Planning Consultation Memo

Date	Planning Officer	Environmental Health Officer
03/01/2020	Clare Howe	Karl Riahi
Planning Application Number	Worksheet Number	
6/2019/2714/OUTLINE	WK/113904

Address: 1 YMCA 90 Peartree Lane Welwyn Garden City AL7 3UL

Application Details: Outline planning application for a hybrid application for demolition of existing hostel, development of a four storey 100 bed YMCA Hostel (All details submitted for determination) and a 2,3 and 4 storey building providing up to 43 residential apartments (All details retained for future determination as reserved matters, except means of access) with associated car parking and landscaping

3.3 NOISE IMPACT ASSESSMENT

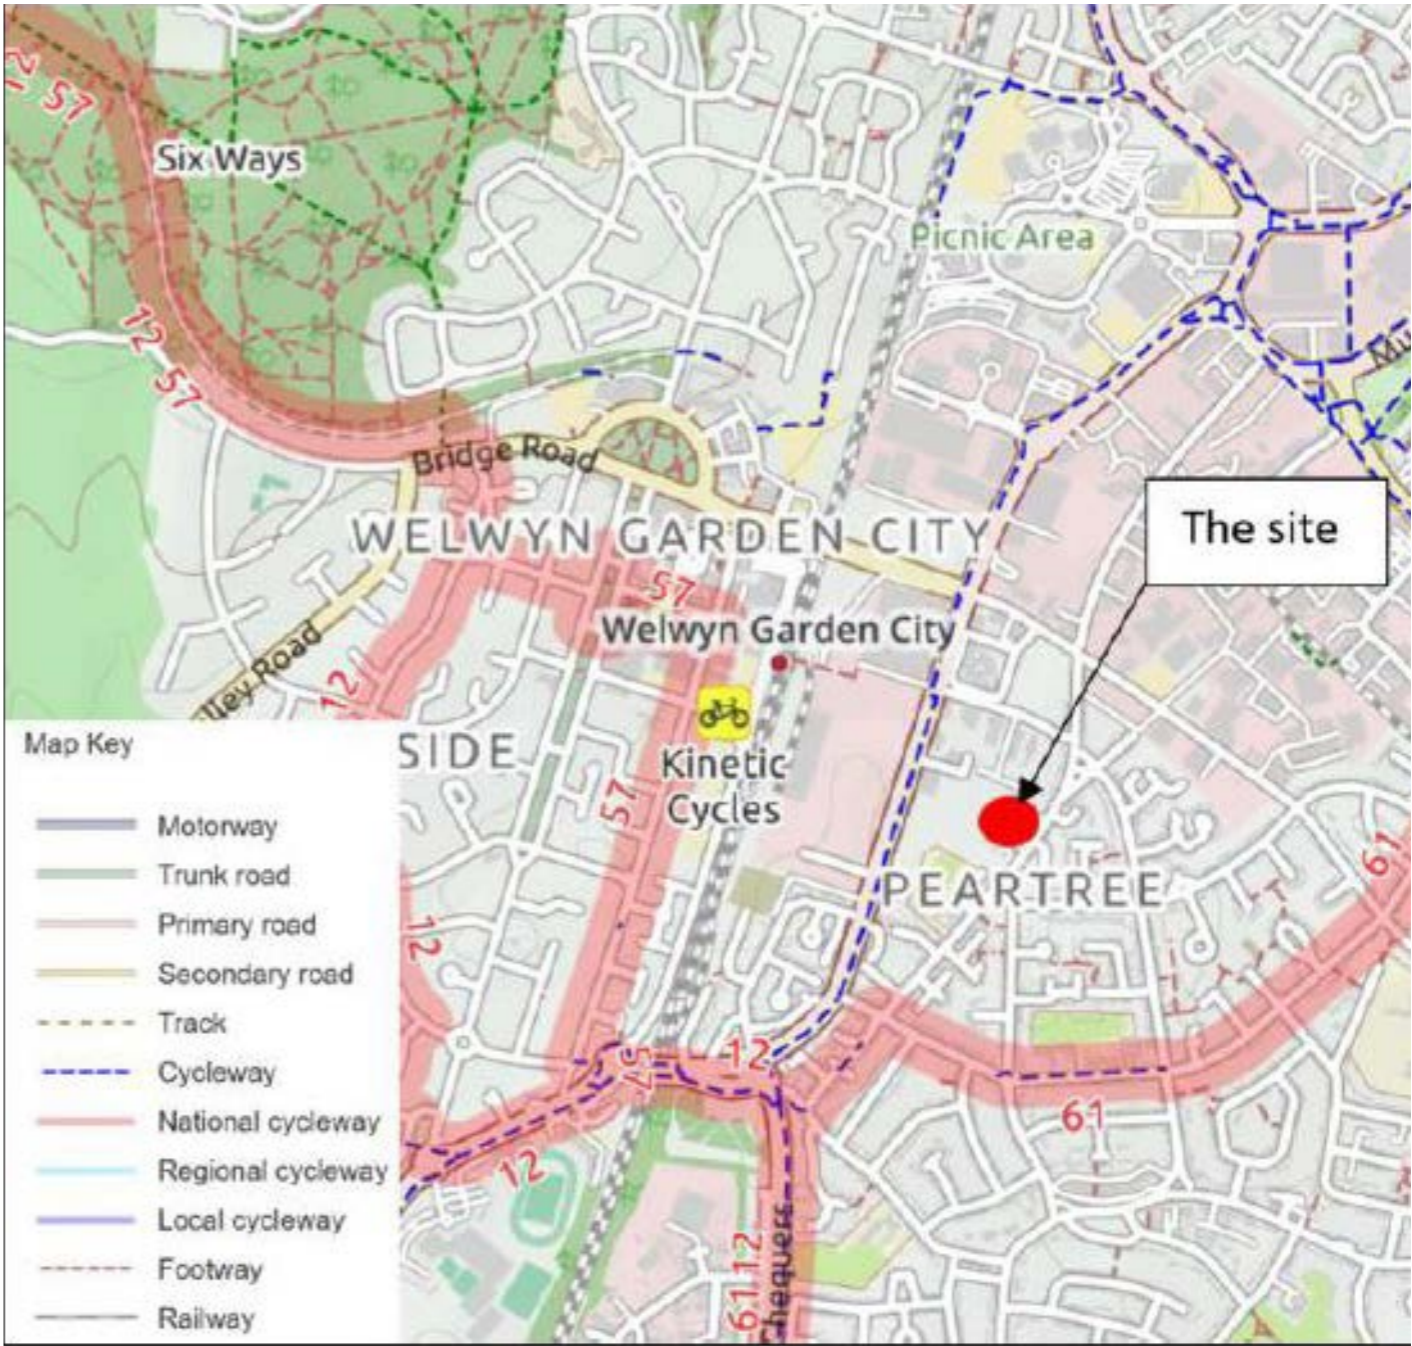
A noise impact assessment provided with the application provides information on the effect that noise from traffic will have on this proposed development.

From assessing the supplied noise maps, there appears to be the potential for some properties to meet the levels within BS8233 with a partially open window (assuming 15dB attenuation). However, for habitable rooms that don't achieve this, then mechanical ventilation will need to be installed which provides the ventilation rates within the Noise Insulation Regulations 1975.

The acoustic report also covers noise from commercial/industrial units and levels measured and expected at facades of residential properties raise serious concerns over the suitability of the scheme. The BS4142 assessment shows that an hour period measured was 17dB over the background noise level, and with a 3dB penalty the rating level being 20dB over the background noise level, although there is no description of the noise to justify this penalty (what created the noise). Max noise levels at the rear have also been shown to be as high as 94.9dB.

As this is essentially a new building and site layout, it is felt that good acoustic design could have been utilised to minimise the potential impacts from commercial/industrial noise, such as with non-habitable or even non residential rooms fronting noise sources.

Prior to any above ground development the applicant shall submit to, for approval in writing by the Local Planning Authority, details relating to a scheme to protect the proposed development from noise due to traffic and the existing and proposed commercial/industrial businesses which shall be implemented before any part of the accommodation hereby approved is occupied, unless the Local Planning Authority otherwise agrees in writing.

For traffic noise the scheme shall ensure that indoor ambient noise levels in living rooms and bedrooms meet the standards within BS8233:2014.

For commercial/industrial noise the scheme shall ensure the indoor ambient noise levels in living rooms and bedrooms are 10dB below the standards within BS 8233:2014 and

L_{Amax} levels are not to exceed 40dB internally with windows closed.

If opening windows raises the noise levels above those listed above, then mechanical ventilation will need to be installed, with ventilation rates required to meet those found within The Noise Insulation Regulations 1975.

FIG 37. LIGHTING DIAGRAM

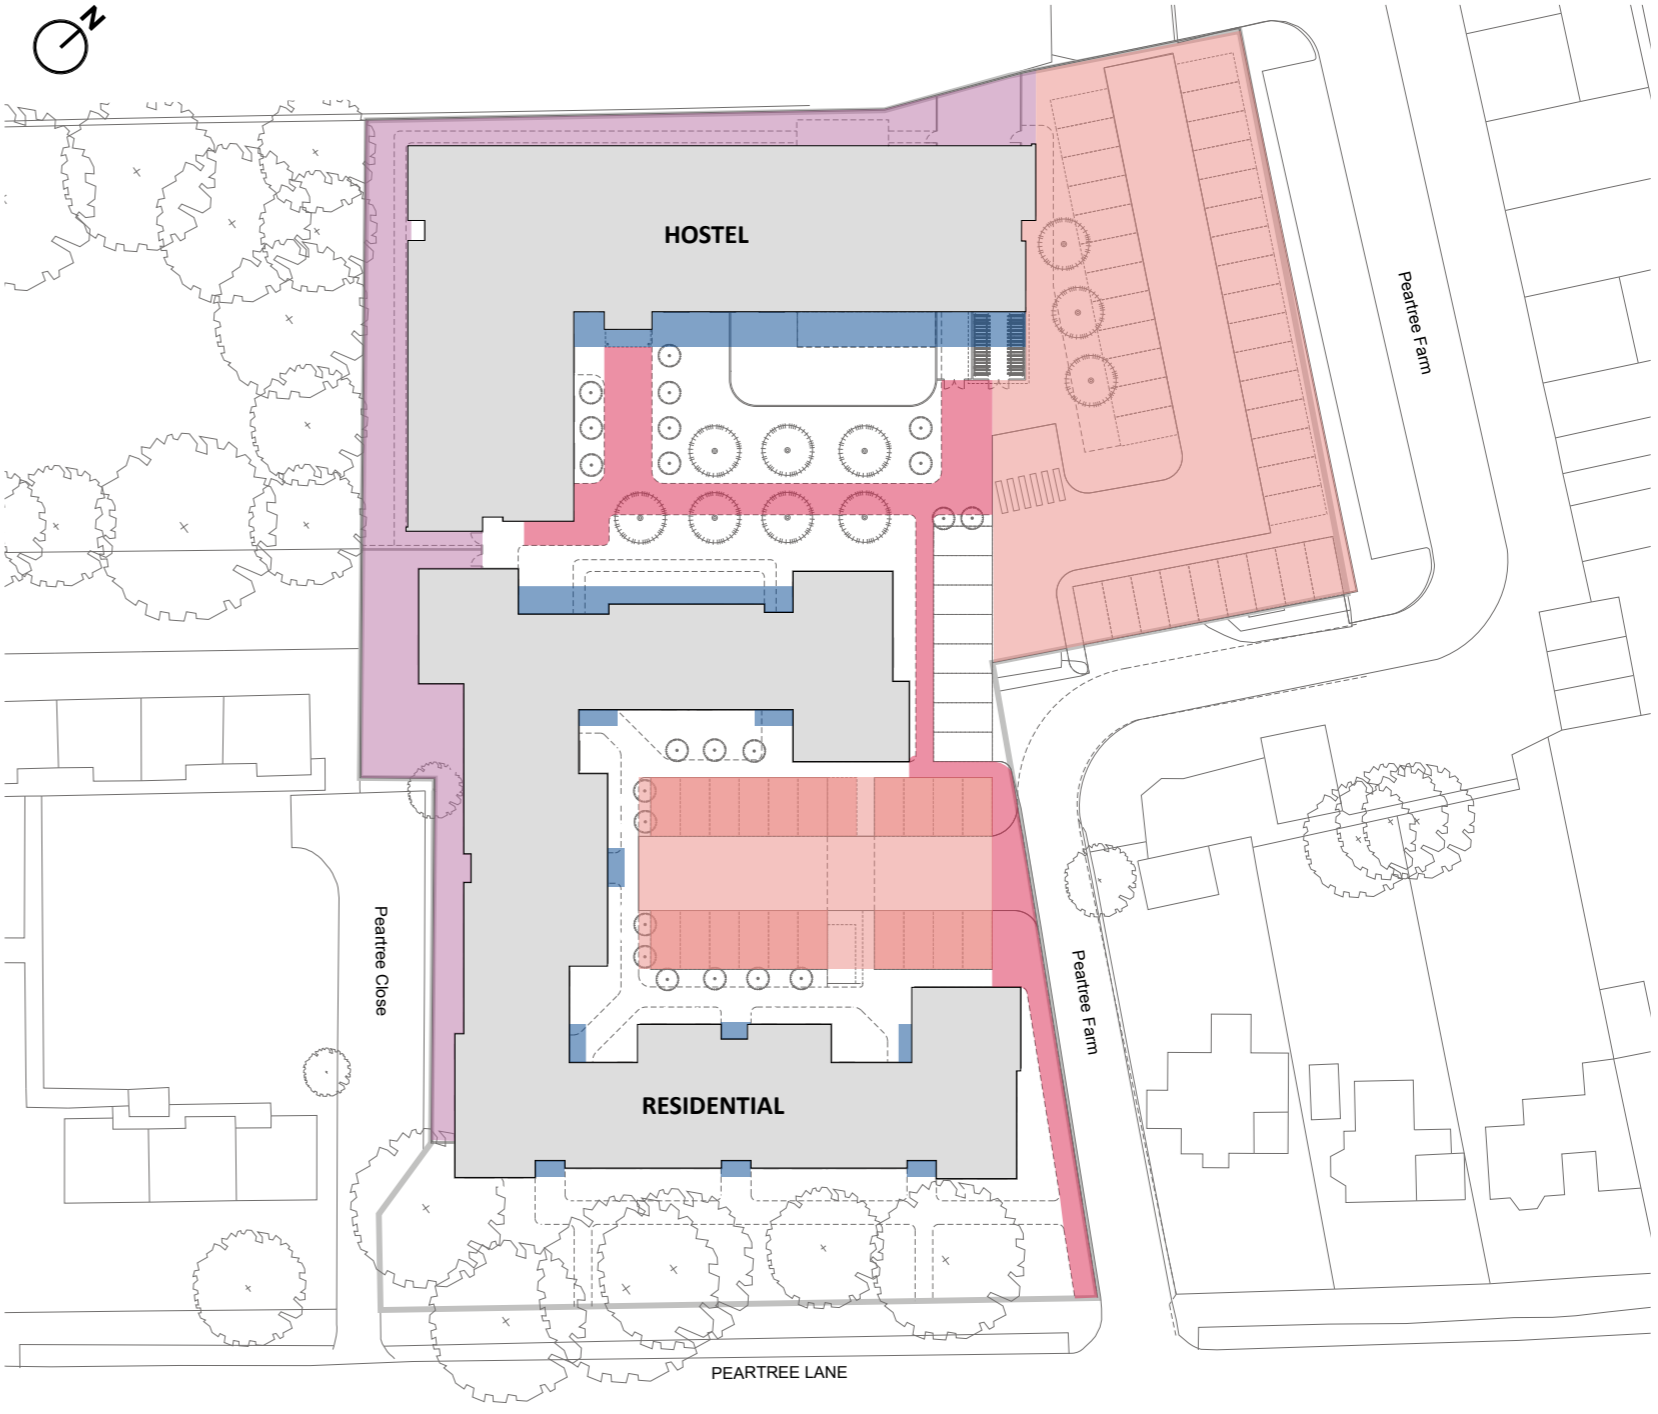
Any external lighting will need to be designed taking into account the ILP guidance in terms of light trespass into windows of sensitive receptors (compliance with the ILP guidance is stated as a criteria within the design and access statement).

Vertical lux diagrams will be required to show that any external lighting will not cause an issue.

Prior to installation of external lighting the applicant shall submit to, for approval in writing by the Local Planning Authority, details relating to the external lighting scheme (including vertical lux diagrams which show potential light trespass into windows of nearby residential properties). This scheme must meet the requirements within the Institution of Lighting Professionals guidance notes for the reduction of obtrusive lighting.
